# KITTITAS COUNTY

### MEMORANDUM

SUBJECT: Kohl Short Plat SP-08-17

Our department has reviewed the short plat application and has the following comments:

KOHL SHORT PLAT
Portion NW 1/4, Sec. 5, T.19N., R.15E., W.M.
Kittitas County, Washington

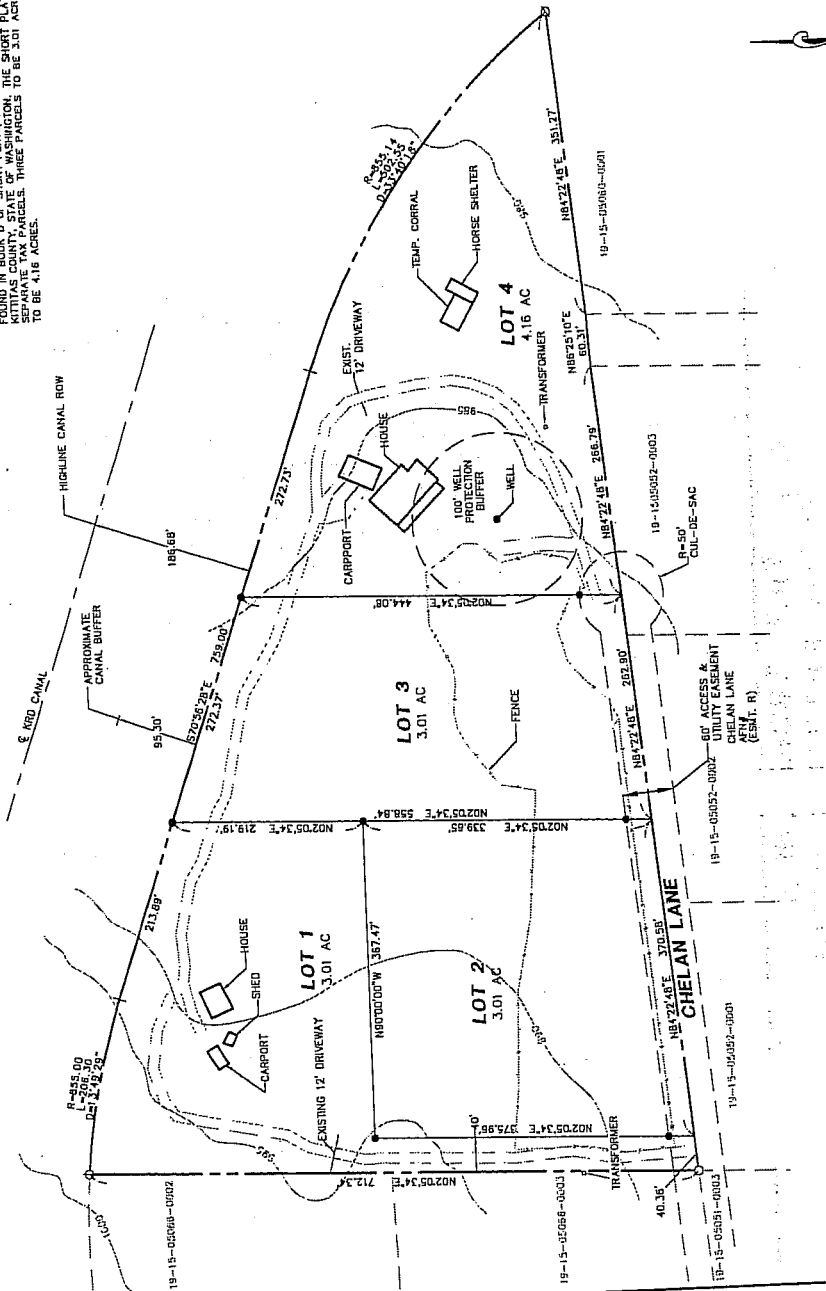
1. **Road Improvements:** This short plat will be required to follow the conditions imposed by the Callaway Short Plat Appeal, Resolution No. 2005-161. Chelan Lane, from the intersection with Westside Road to the cul-de-sac, shall be constructed in accordance with Tables 4-1 and 4-2 of the Kittitas County Road Standards, which require a BST or ACP surface, a 24' road width, and an easement width of 60'.

2. **Cul-de-Sac:** A cul-de-sac turn-around having an outside right-of-way easement diameter of at least 110 feet shall be constructed at the closed end of all dead-end roads serving 3 or more lots. The driving surface shall be at least 96 feet in diameter. Cul-de-sacs must also conform to the requirements specified by the 2006 International Fire Code. Contact the Fire Marshal regarding any additional cul-de-sac requirements.

3. **Joint-Use Driveway:** A joint-use access shall serve no more than two tax parcels. See Kittitas County Road Standards, 9/6/05 edition.
  - a. Access easements shall be a minimum of 20' wide. The roadway width shall have a minimum width of 12'.

- a. There are two plat notes with the number 8. One should be number 7.
  - b. The second sentence of plat note number 4 is incorrect. It should read: See Kittitas County Road Standards.
